City of Albuquerque

Re: Drainage Plan for Lots 9 and 10, Block 2, Trotter Addition,
Dated December 7, 1982

## DRAINAGE PLAN

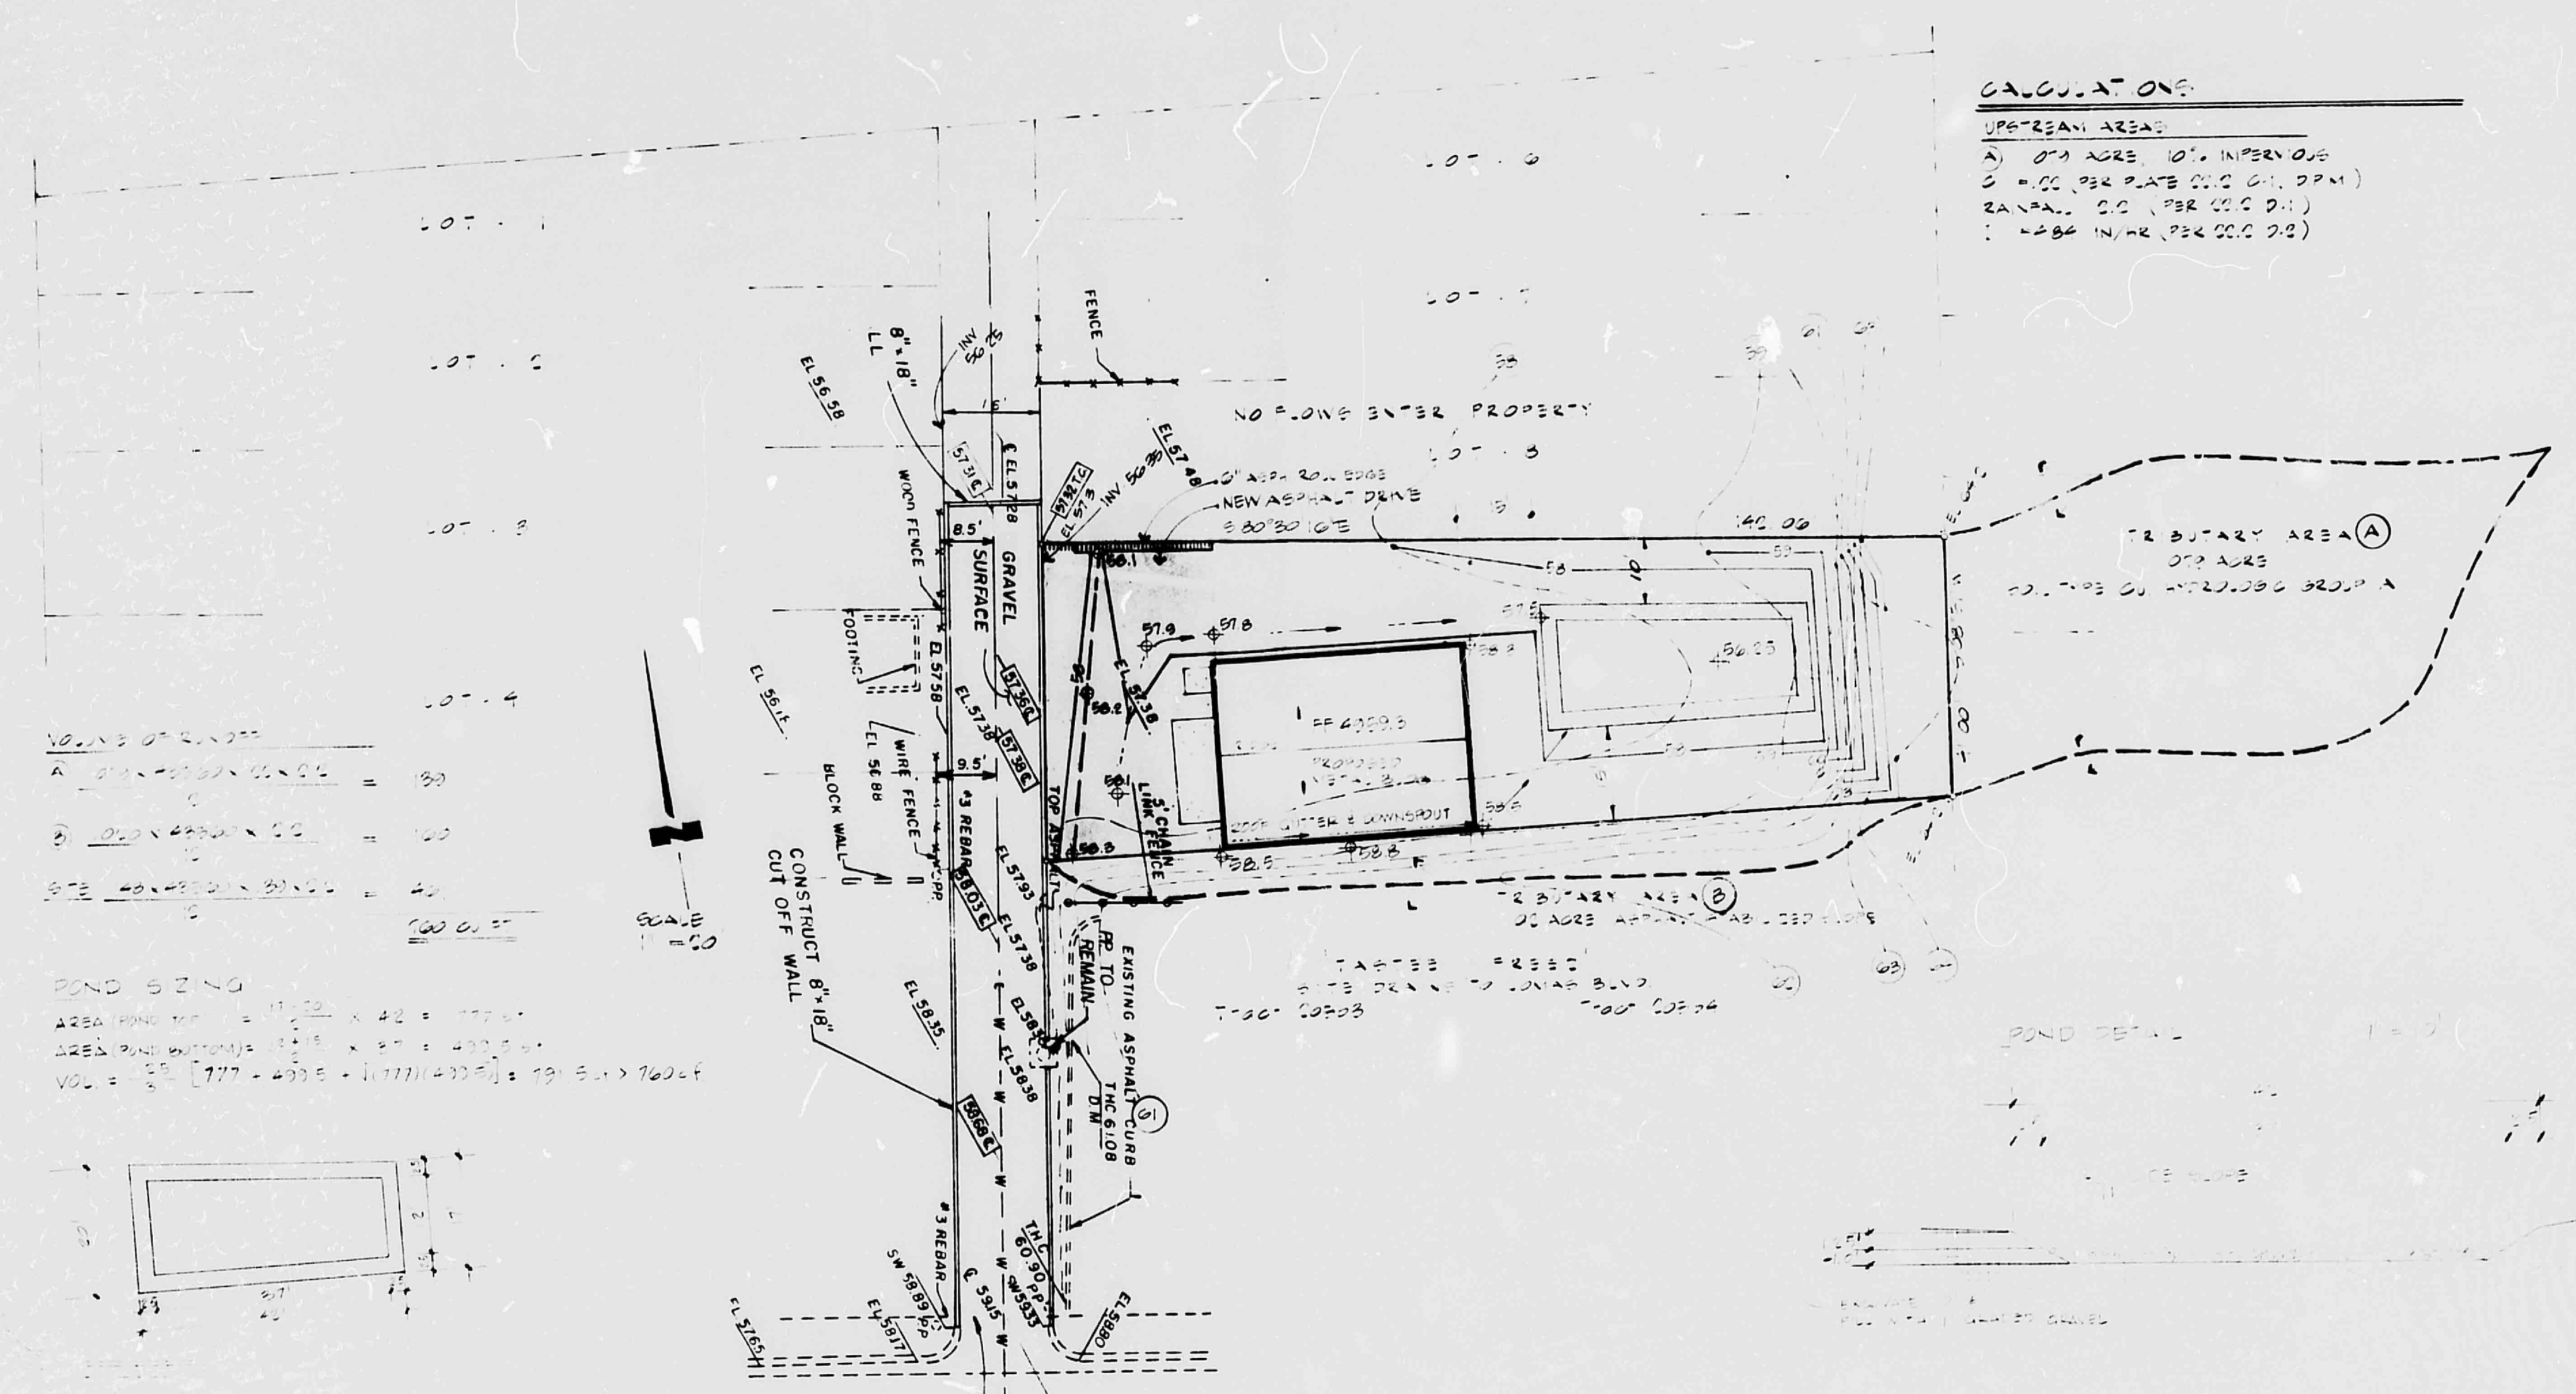
The referenced plan received December 10, 1982 is being returned for noncompliance with the Drainage Ordinance which requires discharge of the pond.

Please provide a revised plan with provisions for discharge into a public right-of-way as required by the Drainage Ordinance and outlined by the Development Process Manual, Volume 2, Section 22.7.
